City of Portland, Maine - Building or Use Permit Application

Permit No: 05-1536 Issue Date: NOV 2 2 2005 CBI#: 342 B028001

TO: Inspections Department
FROM: Jay Reynolds, Development Review Coordinator
DATE: March 15, 2006
RE: C. of O. for #52 Ruby Lane, Lot 10 Oak Ridge Subdivision
(Id#2005-0194)(CBL 371A037)

52 Ruby Lane #10 Staff Review Checklist

FRONT ELEVATION

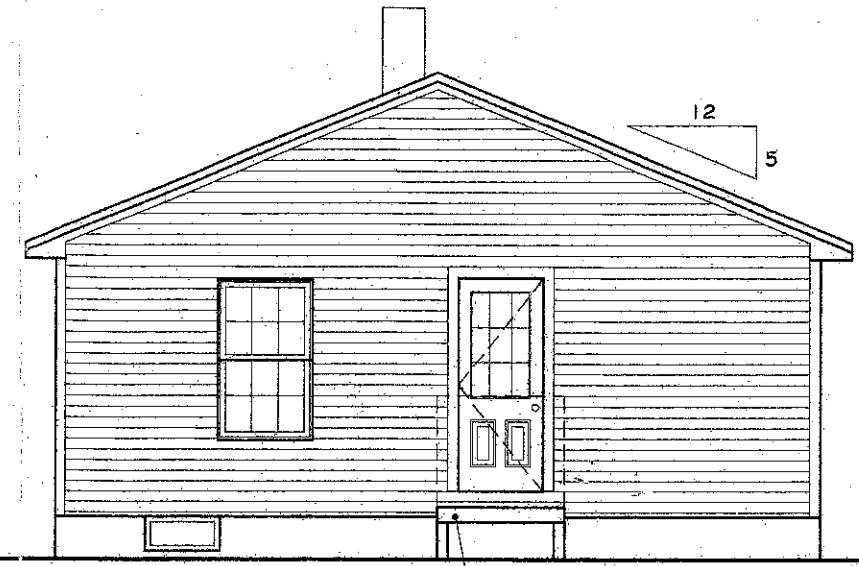
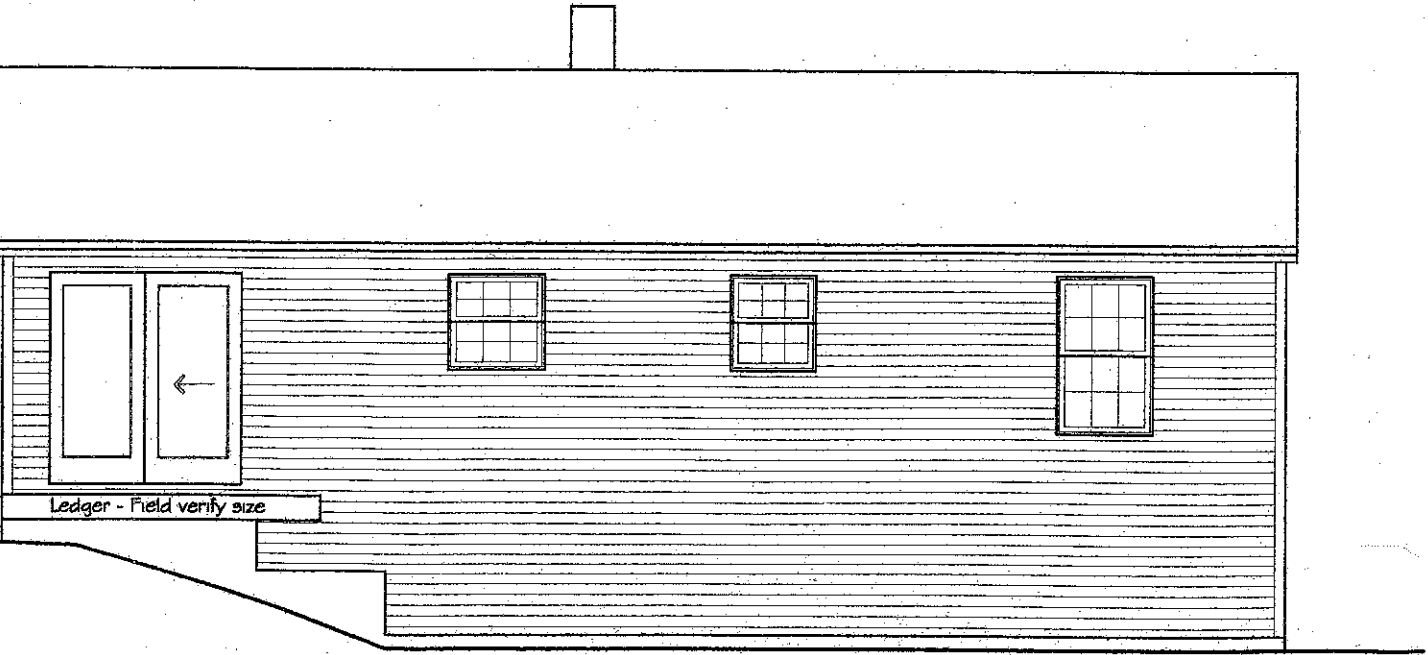
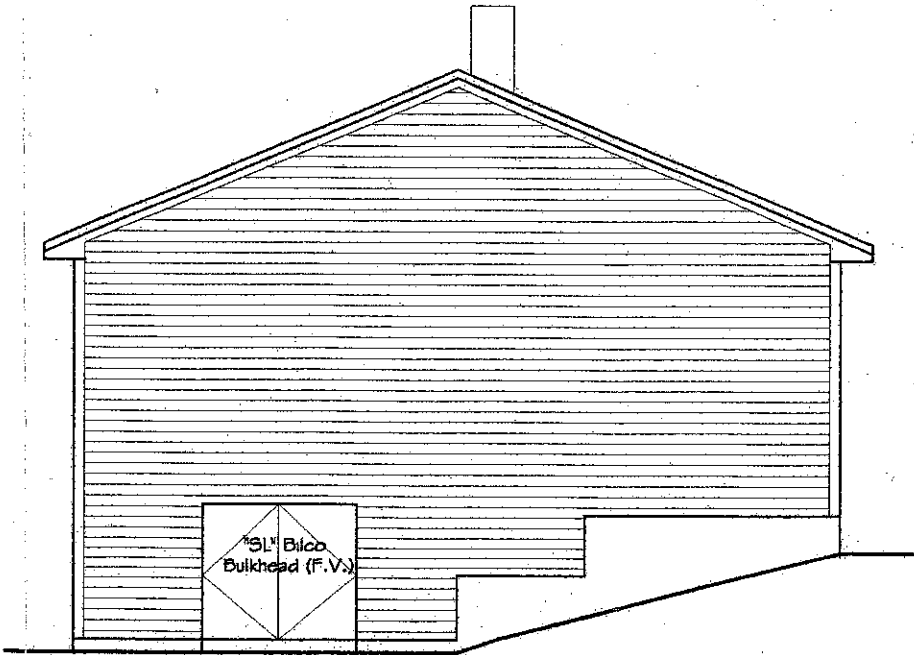
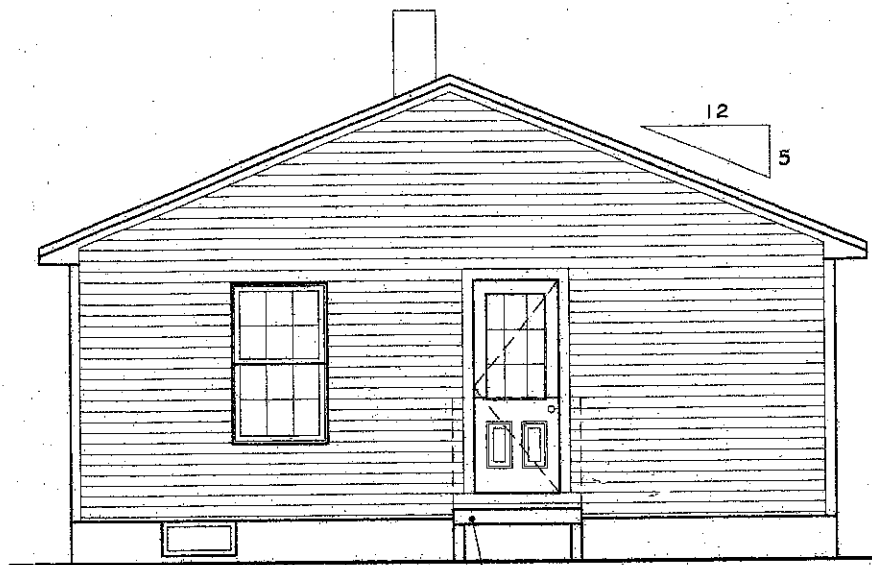
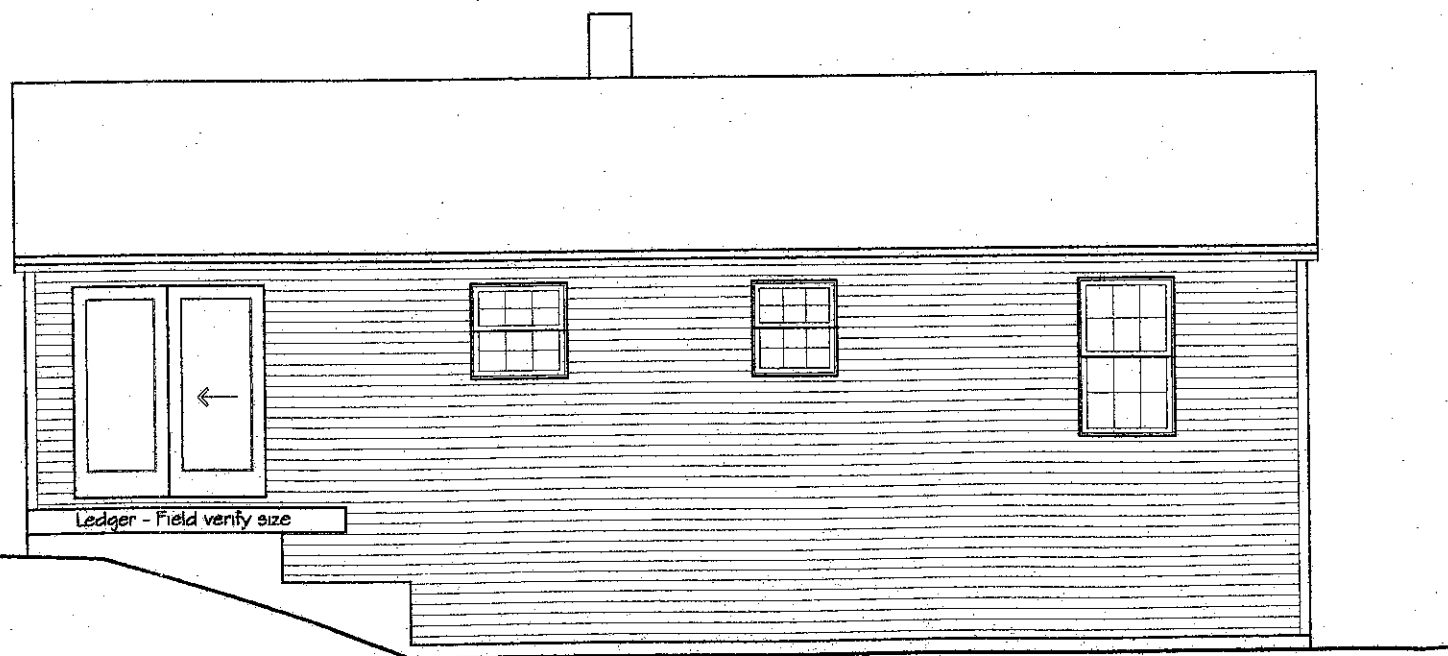
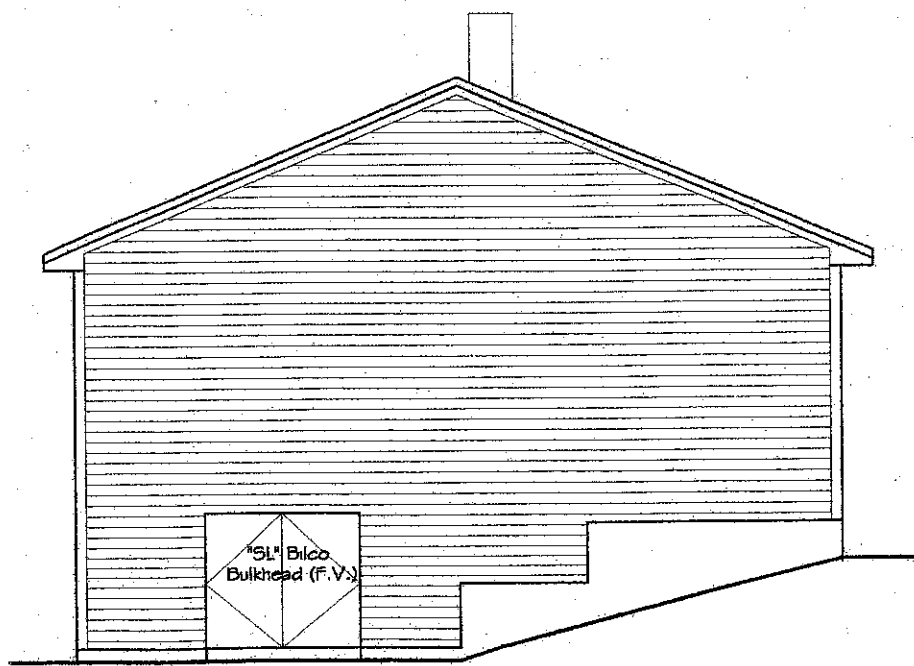
Note: 11/01/05 Left message w/Dan. Need a deed, elevation plans not to scale & left & right sides confused, new **OK to Issue:** site plan that shows bulkhead and side entry, & need to take out double doors on first floor plan because no room for deck out back.
